Response to Submissions

State Significant Development Application – Shade Structures at the Overseas Passenger Terminal (Tenancy 5), Circular Quay West in The Rocks (SSD 9334)

Revised Plans – Sun Shade Structures and Awnings, Tenancy 5 of the Overseas Passenger Terminal

Level 01 - Ground Floor

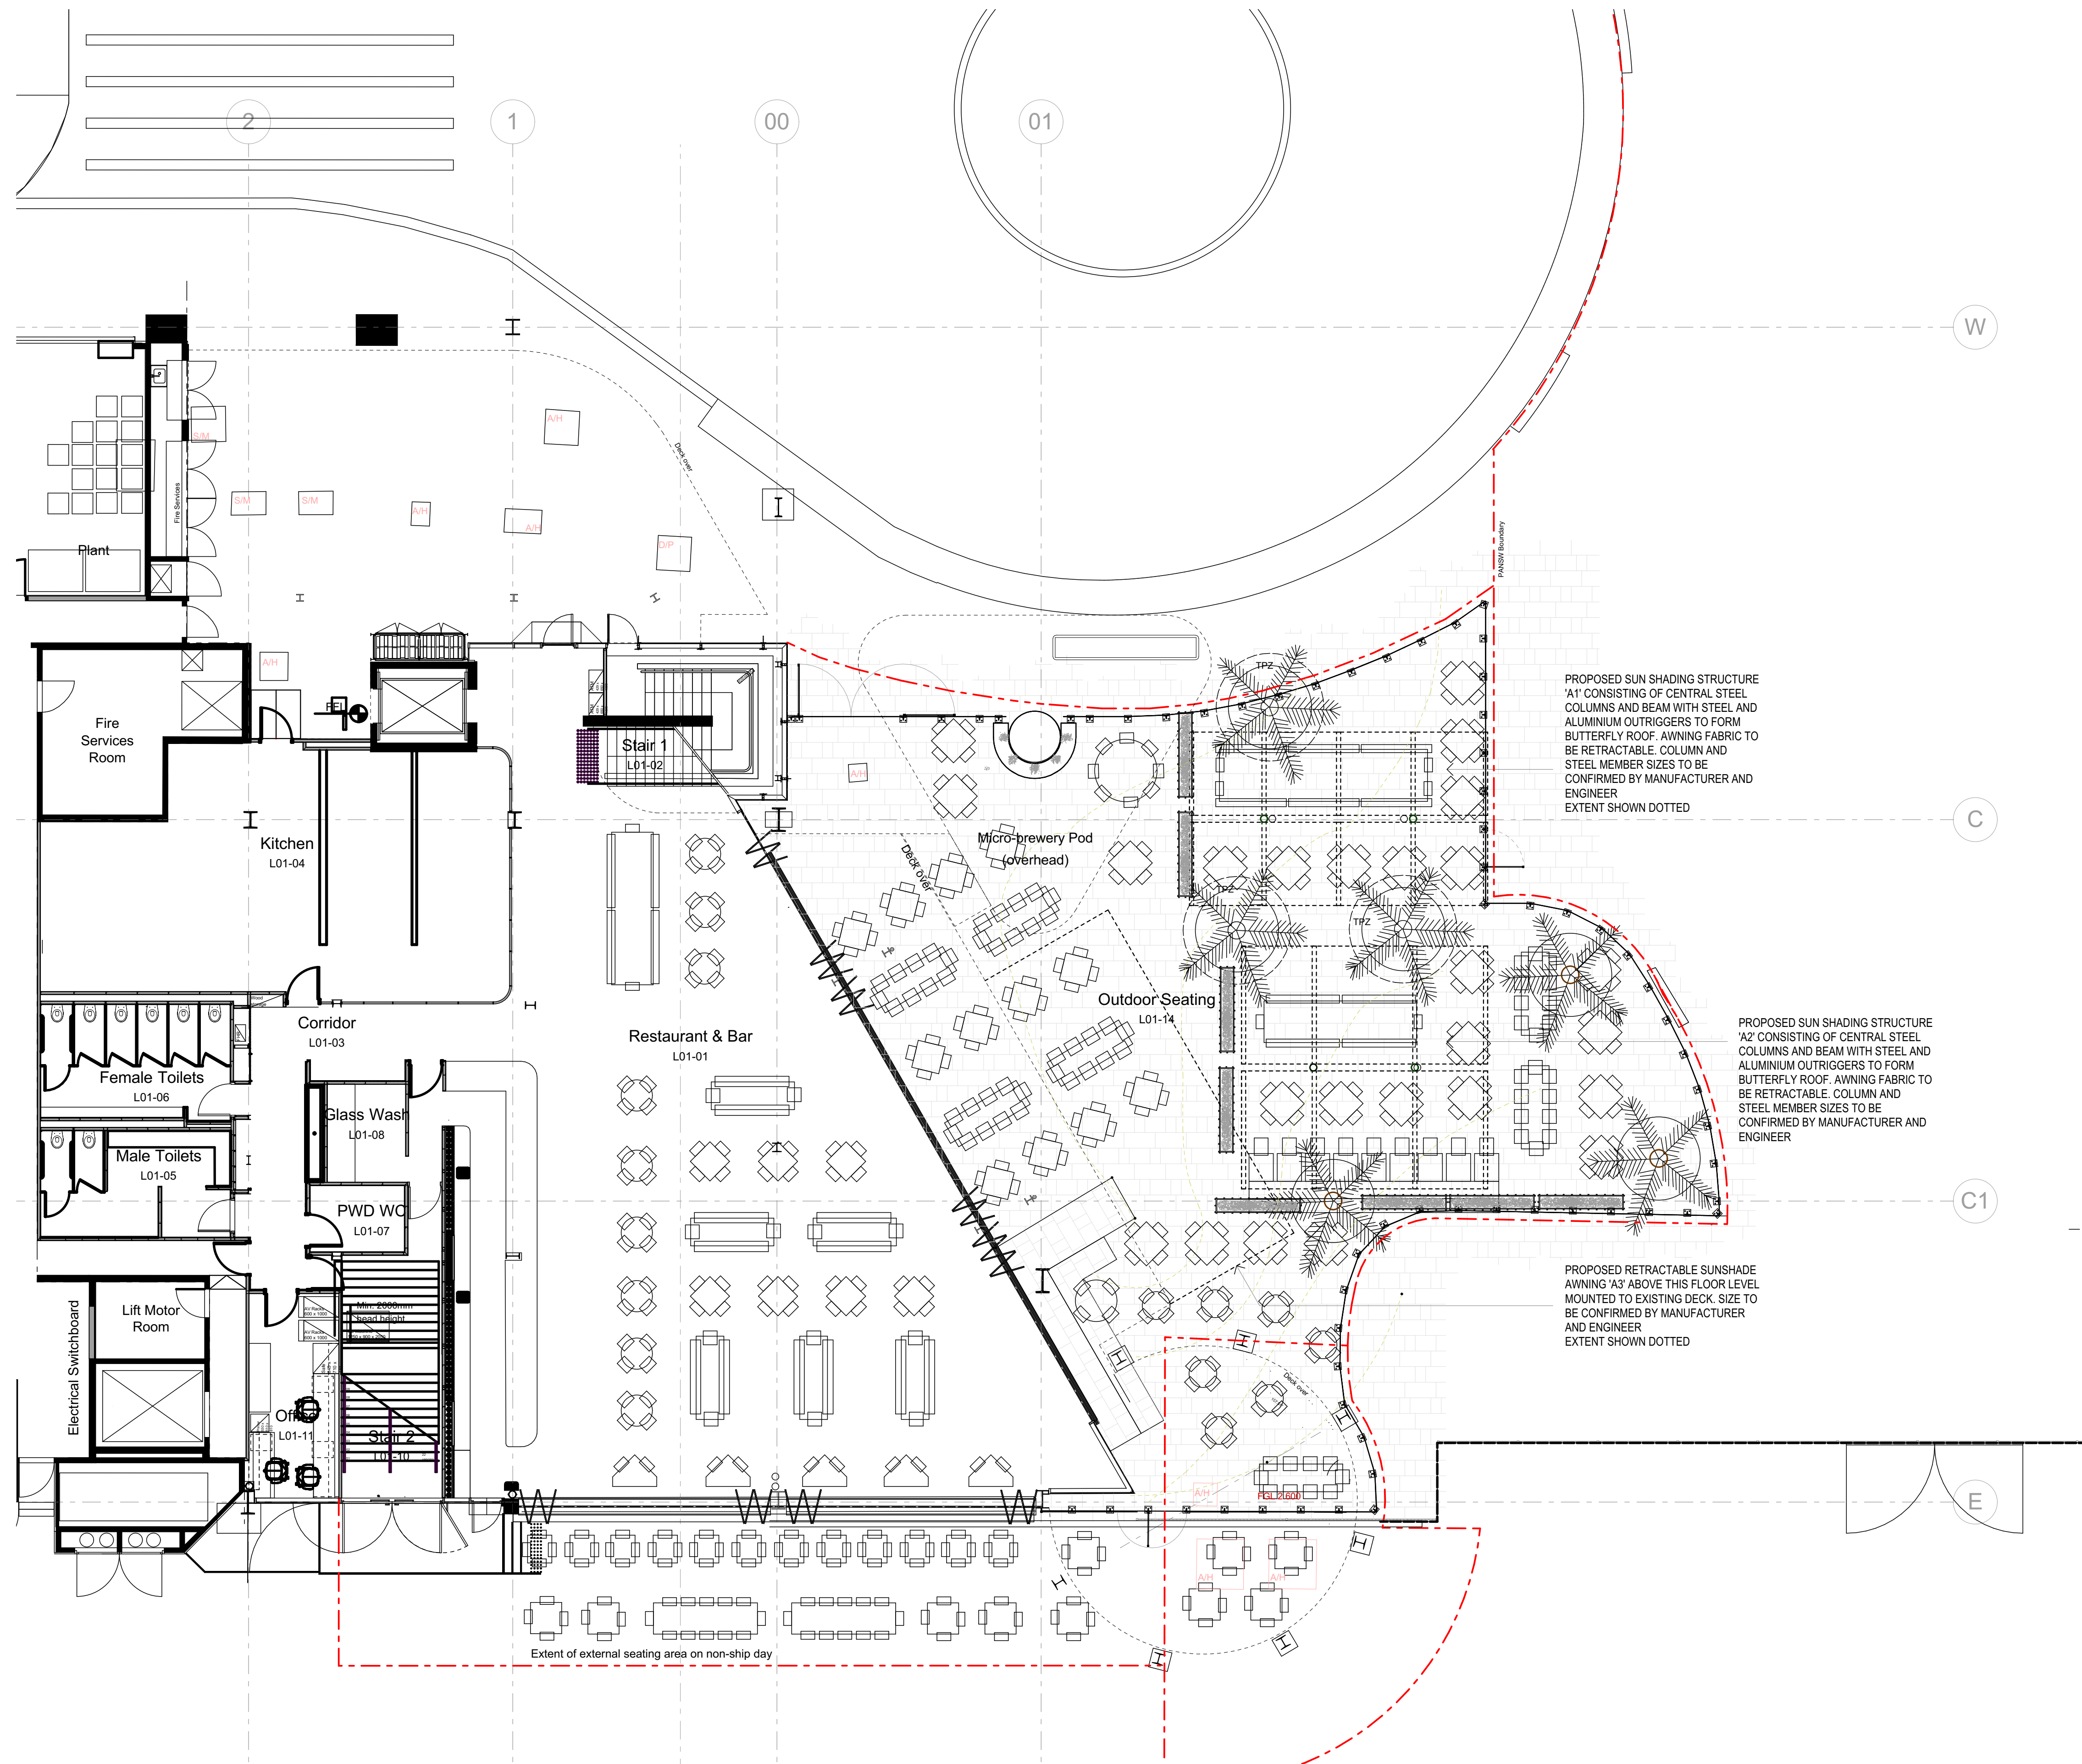
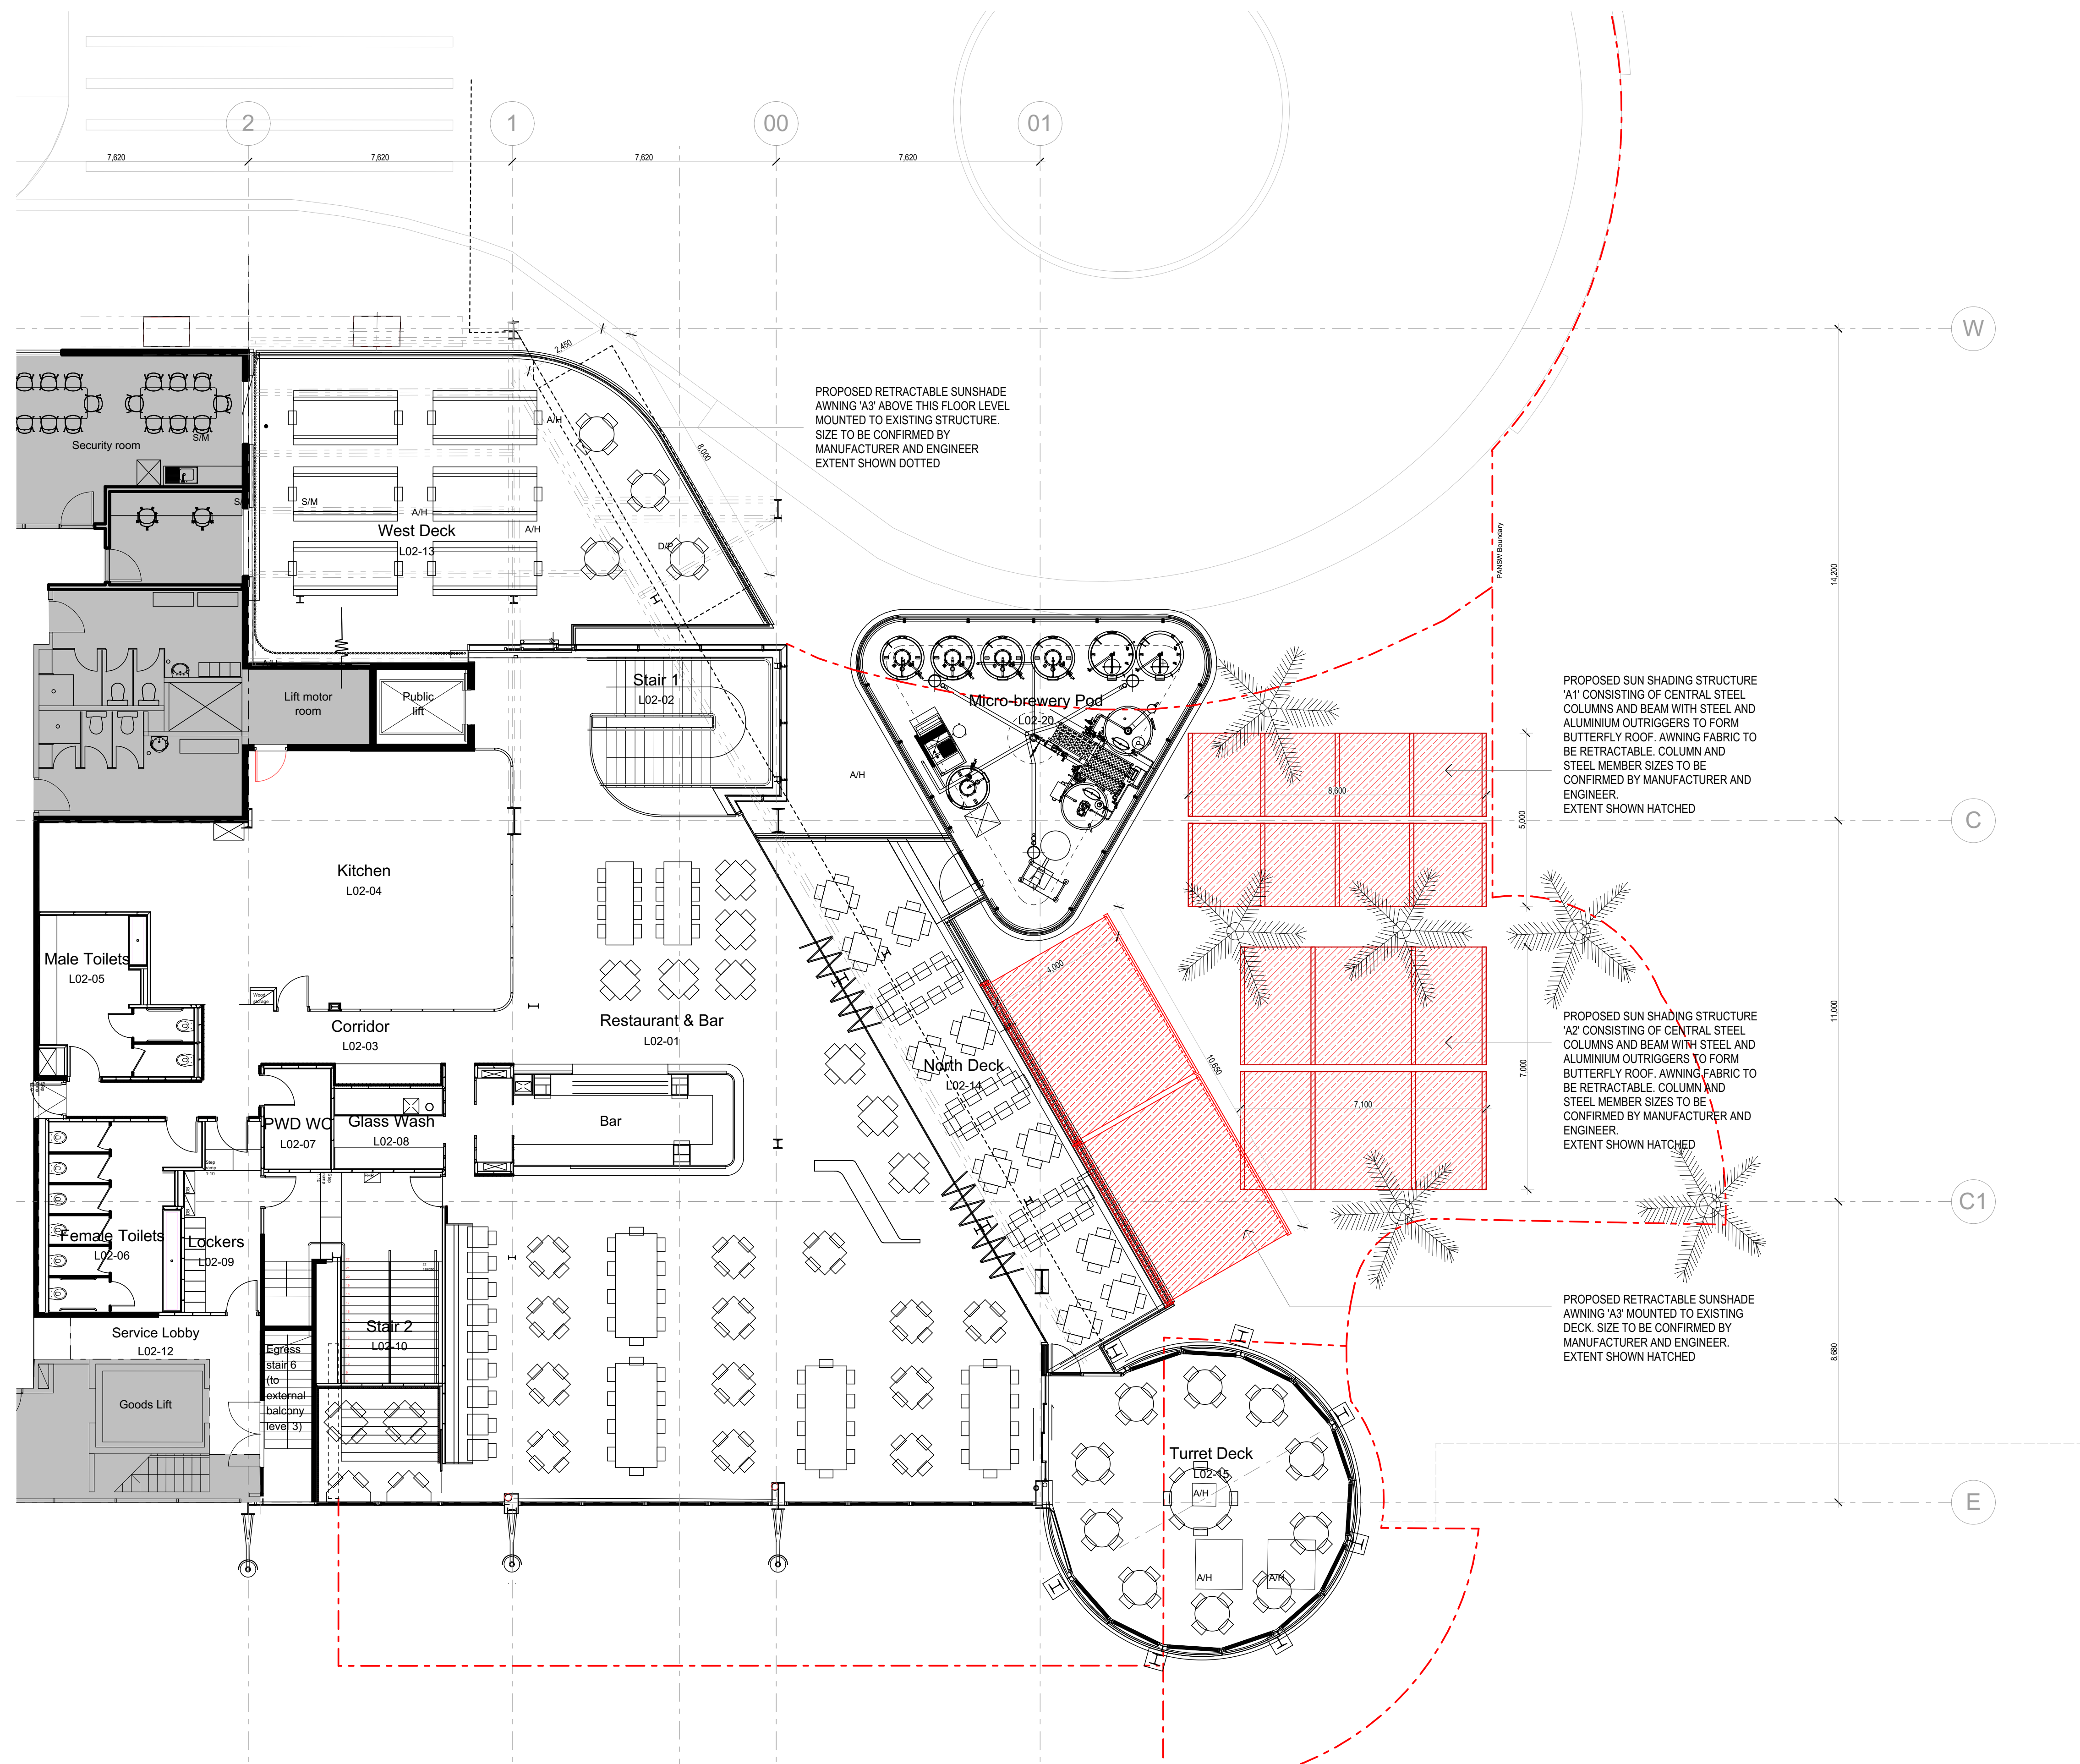
A3	<p>With respect to the two retractable free standing shade structures (A1 and A2), the City would like to draw the Department's attention to those aspects of the proposal that appear to require further resolution:</p> <ul style="list-style-type: none"> Parts of the shade structures 'A2' and 'A3' overlap, which contradicts the elevation where they appear to be at the same height. How do they integrate with each other and will this affect their operability? 	<p>There is a small overlap for shade structures A2 and A3. Proposed structure A3 (which will be mounted to the existing deck) would be positioned approximately 250mm lower than shade structure A2. There will be no impact on the operability of either structure.</p> <p>The overlap of structures A2 and A3 are shown in the revised plan set at Appendix C (refer plans TSL DD-100-SK02 C and TSL DD-100-SK12 A).</p>
A4	<ul style="list-style-type: none"> The view analysis image labelled 'View 1 – Proposed' is somewhat misleading as the proposed structures are shown to be in the shade and a grey colour. Perhaps they are shown in a retracted position which is less helpful. The application indicates that the fabric will be an off-white colour, which should be properly reflected in the view analysis material submitted. 	<p>The view analysis image is an indicative view only and is considered to provide an appropriate representation of the proposed shade structures, as viewed from the eastern side of Sydney Cove.</p> <p>Notwithstanding, a revised view analysis showing the shading fabric as an off-white colour has been prepared and is submitted as part of the RtS (refer revised plan set at Appendix C). The revised view analysis demonstrates that there will be a negligible visual impact.</p>

Ref.	Agency and issues raised	Response
A5	<ul style="list-style-type: none"> The detail submitted indicates that the column and steel member sizes for the free standing structures is yet to be confirmed by the manufacturer and engineer. At this stage the thickness of the columns should be known so their likely appearance is fully understood. 	<p>Shade structures A1 and A2 will each consist of central steel columns and beams with steel and aluminium outriggers to form a butterfly roof. The central columns will be approximately 250mm x 8mm and the spine beams approximately 250mm x 6mm. The thickness of the columns and beams are detailed in the revised plan set at Appendix C.</p>
A6	<p>The City are of the view that the shade structures 'A3' and 'A4' will likely contribute to visual clutter especially if left unretracted for prolonged periods.</p>	<p>Awnings A3 and A4 will provide the benefit of sun shade and weather protection on the northern deck. The slim profile and simple design of the awnings will minimise any visual impact. The awnings are fully cantilevered and do not incorporate the use of columns to order to minimise visual clutter.</p> <p>Pull down blinds are not included as part of the design of the awnings. When not required for sun shade or weather protection, the awnings are designed to retract into a slim and visually unobtrusive metal casing. The awnings will only be extended during the day and will be retracted during the evening (expect during wet weather).</p> <p>Further, it is considered that any sun-shading alternative (such as shade umbrellas) are likely to be more visually obtrusive than what is proposed as part of the application.</p>
